24 August 2017

Roads and Maritime Reference: SYD16/00527/03 (A18618599)  
DP&E Ref: SSD7610

EXHIBITION OF EIS FOR ALTERATIONS AND ADDITIONS INNER SYDNEY HIGH SCHOOL  
SURRY HILLS

## Attachment A Detailed Comments and Assessment Requirements

DRAWING TITLE
CIVIL ENGINEERING PACKAGE
DRIVEWAY LONGITUDINAL SECTIONS

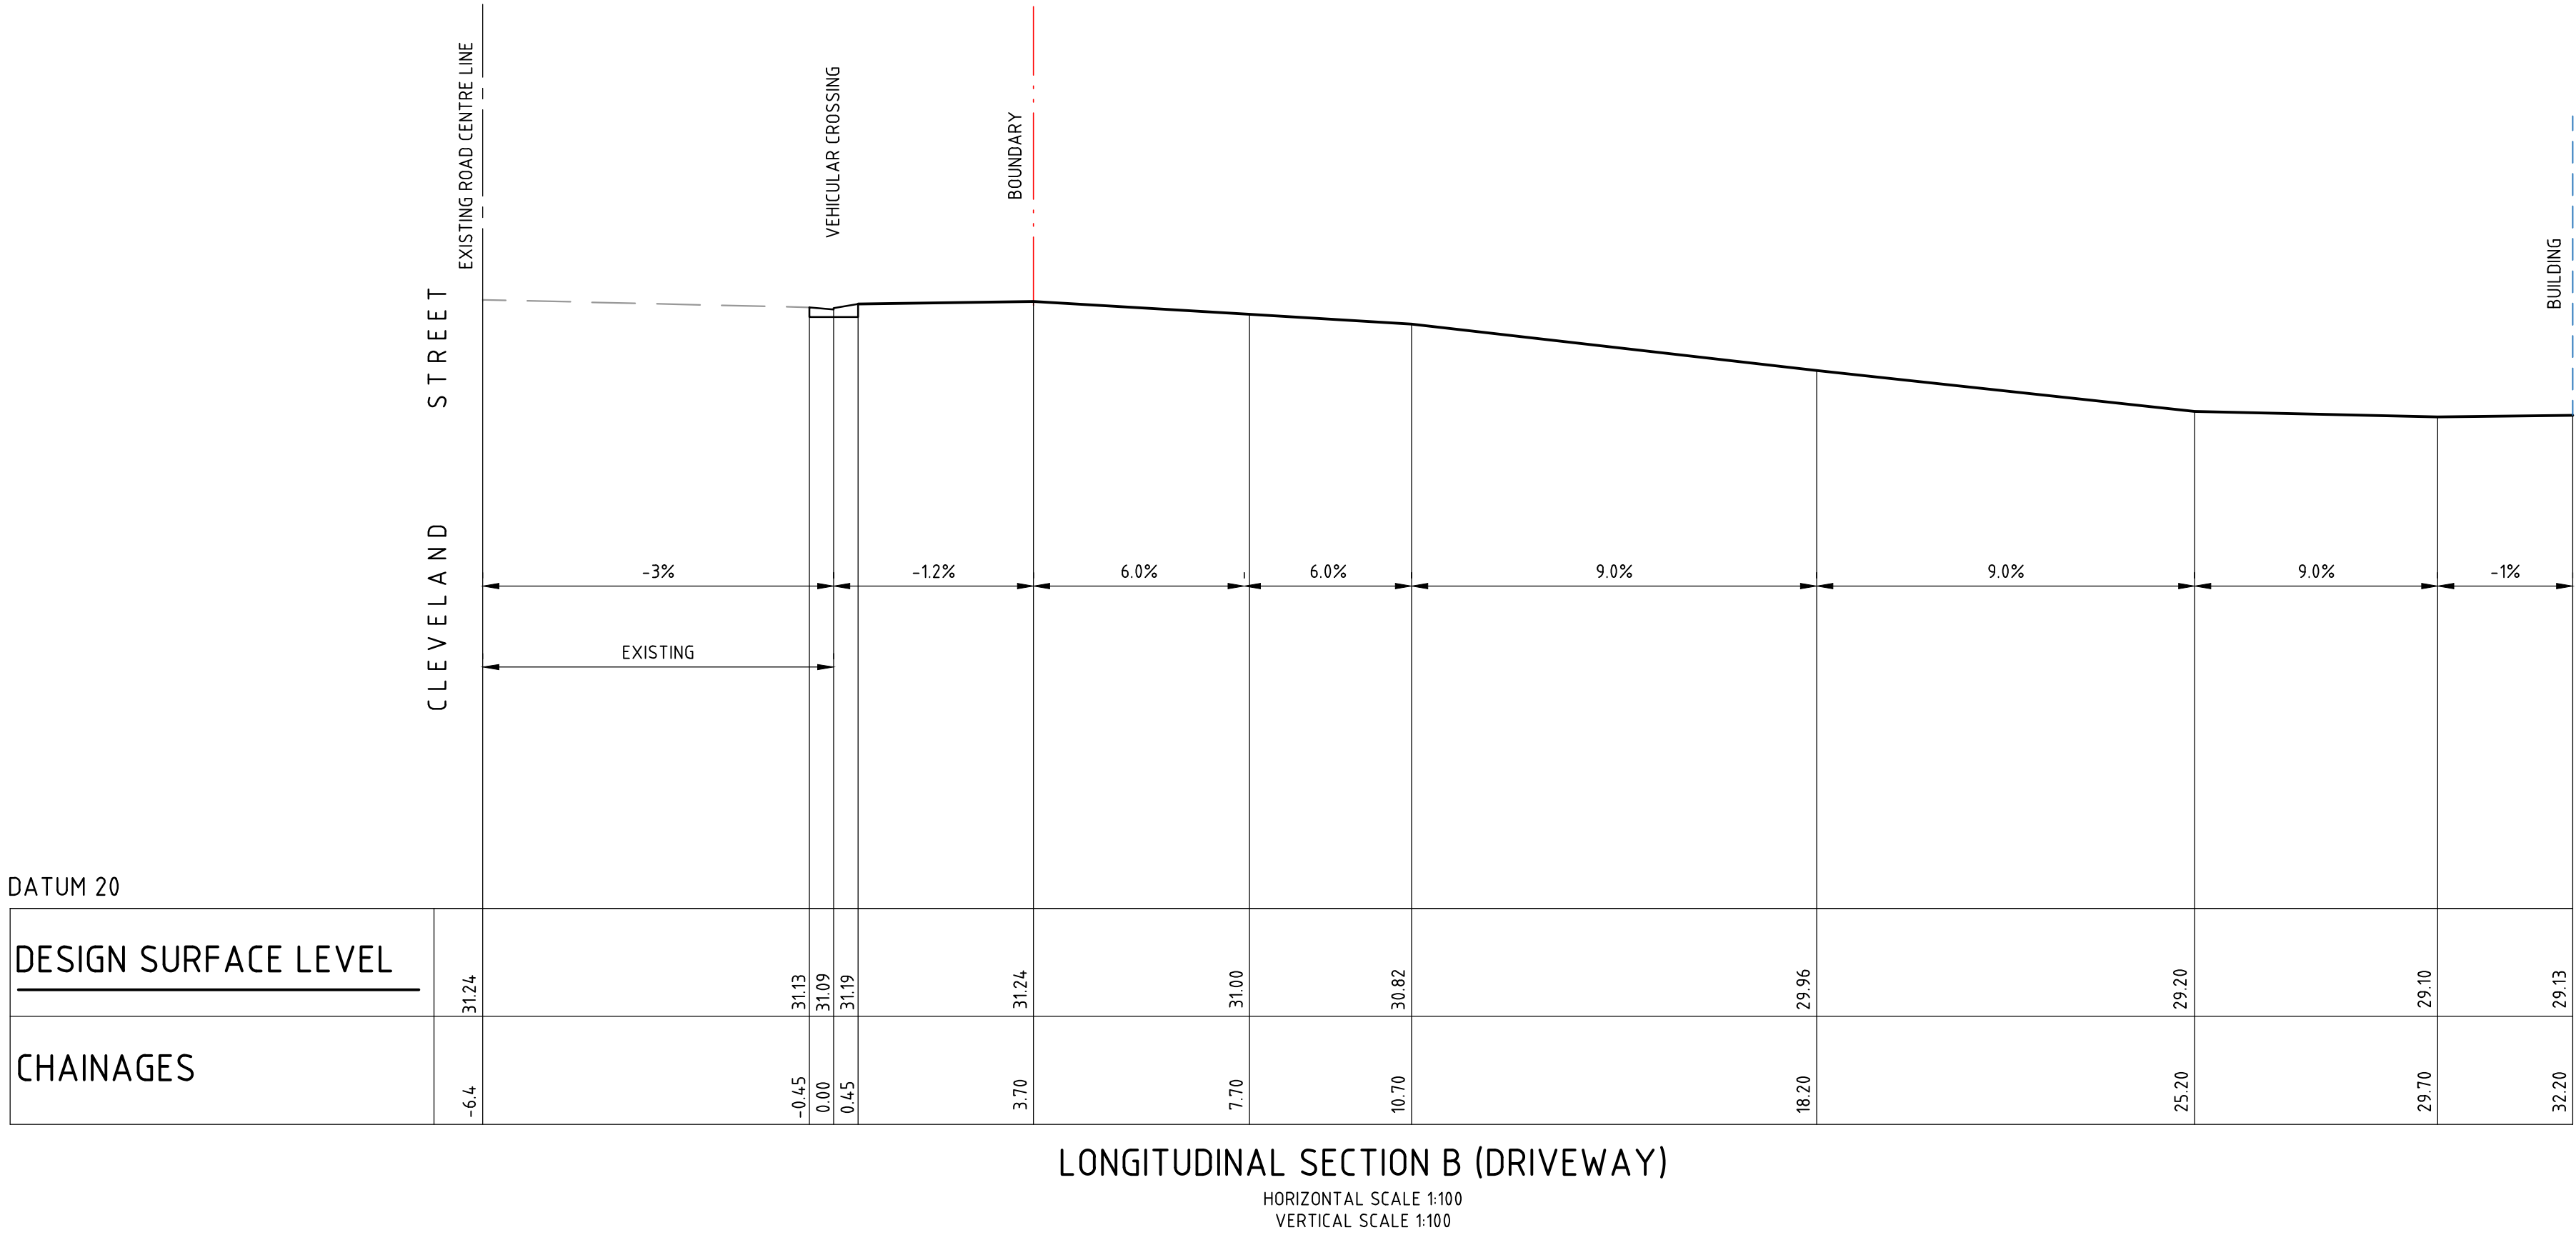
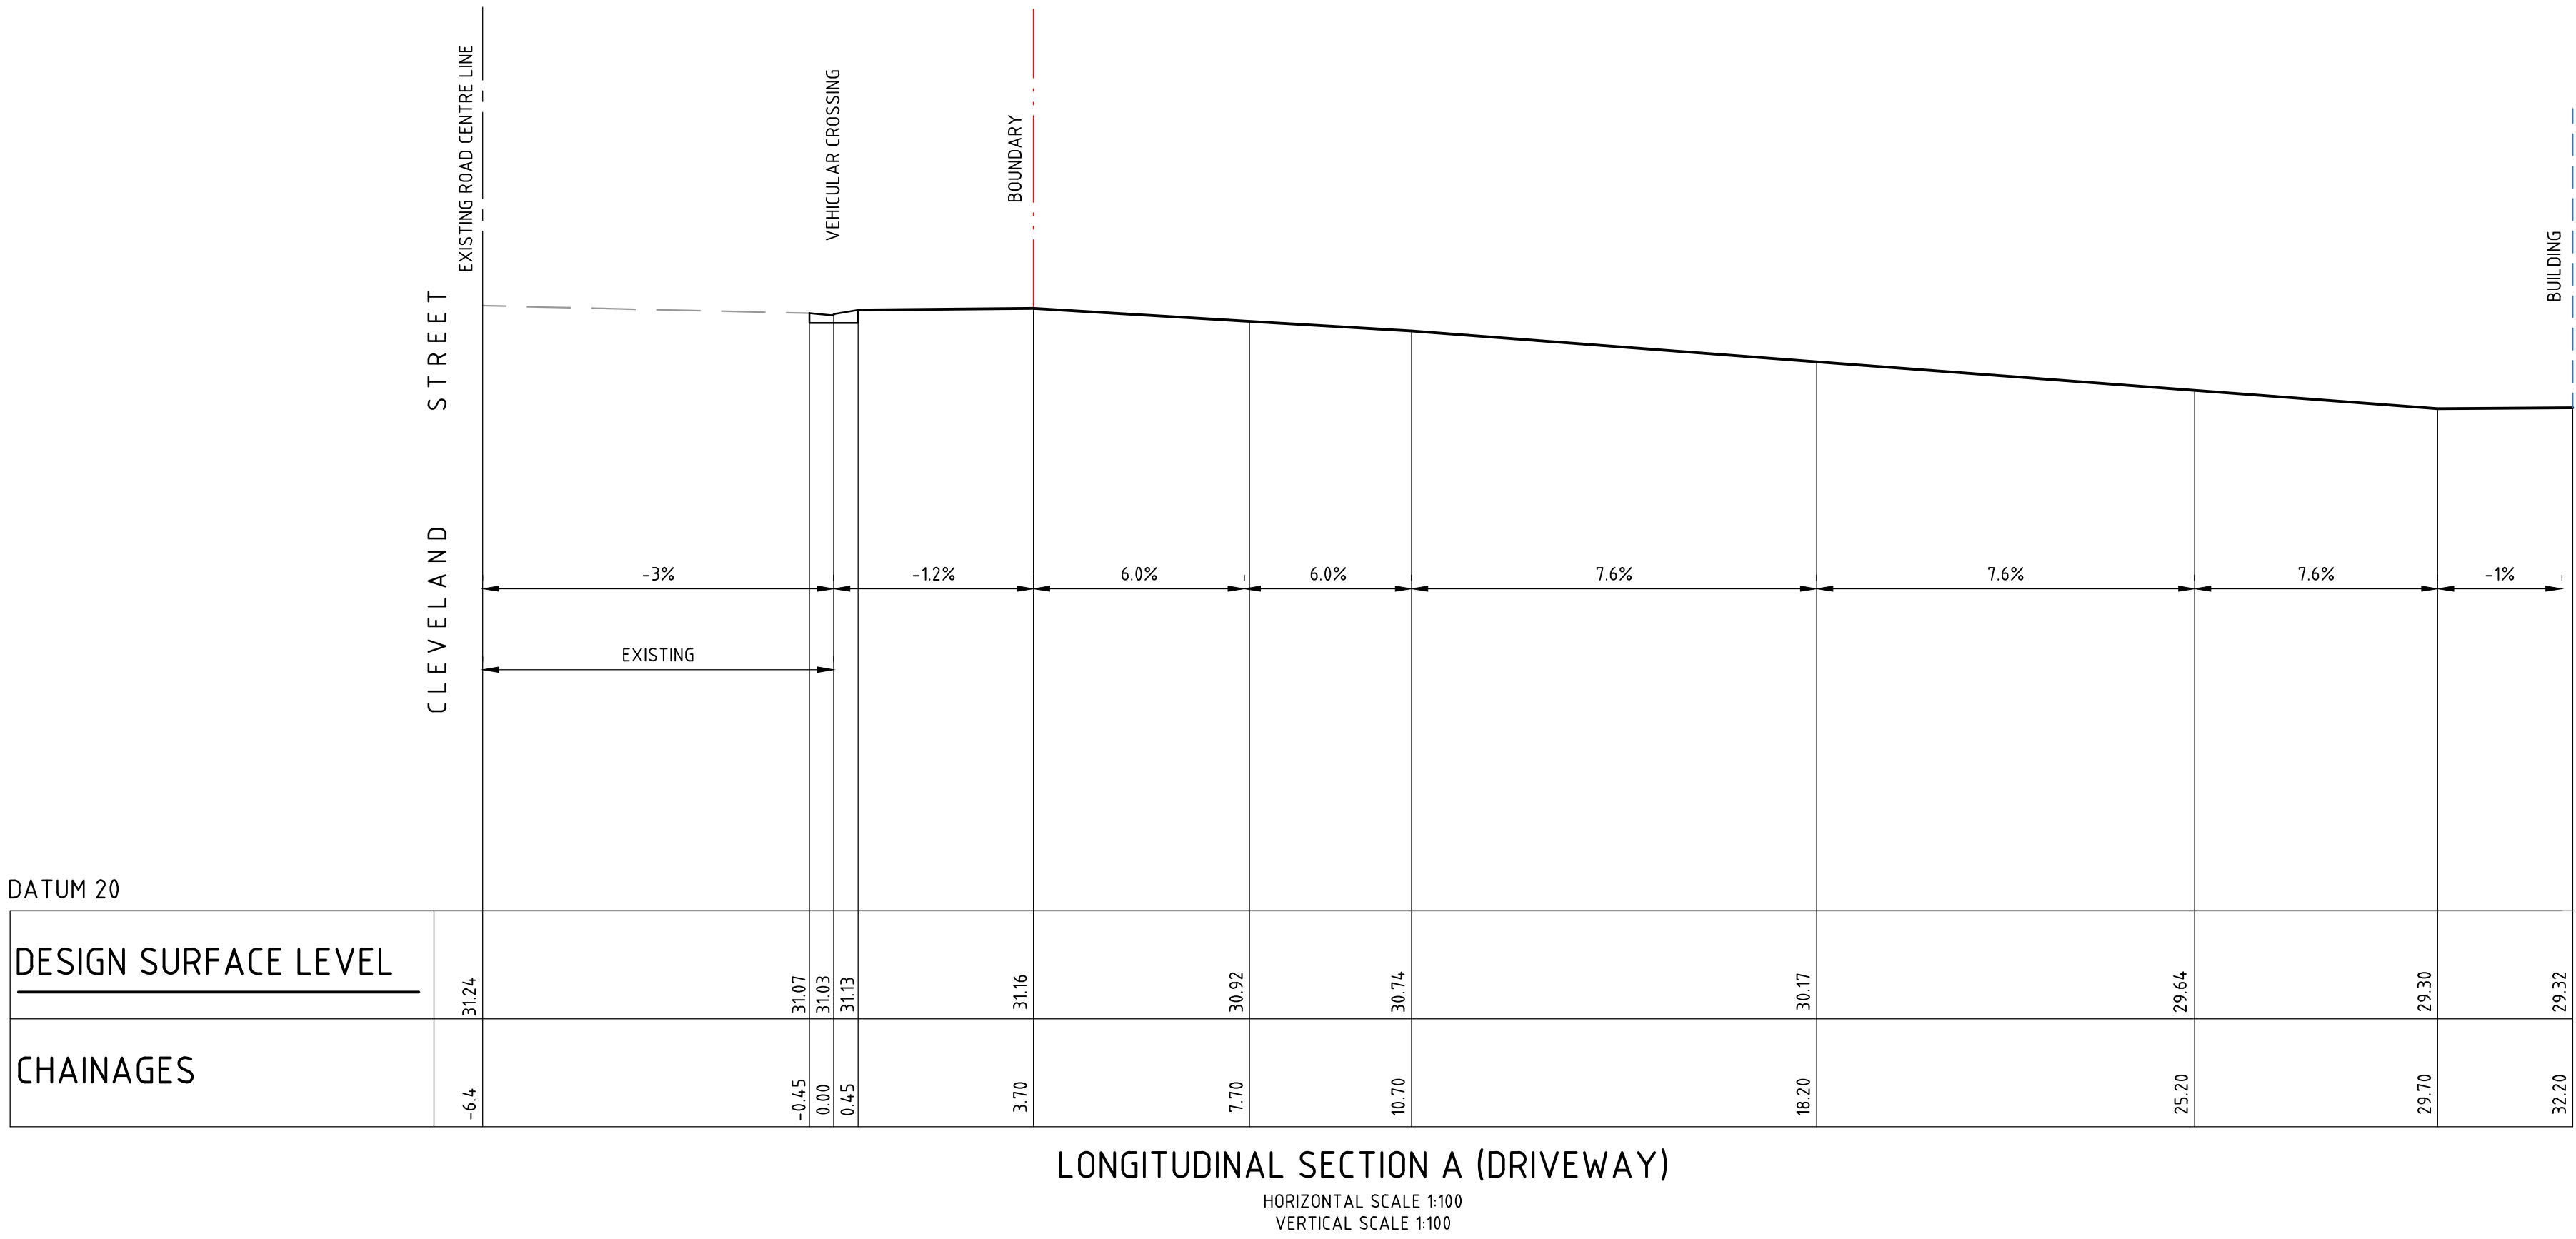
The vehicle swept path plan provided does not show detail of the vehicle crossover on Cleveland Street. The swept path plan should be amended to show detail of the crossover and driveway to demonstrate that the largest design vehicle can enter and exit the site in a forward direction, and manoeuvre to loading areas. Should any driveway adjustment works be required, this should be identified in the plans and submitted for Roads and Maritime's review.
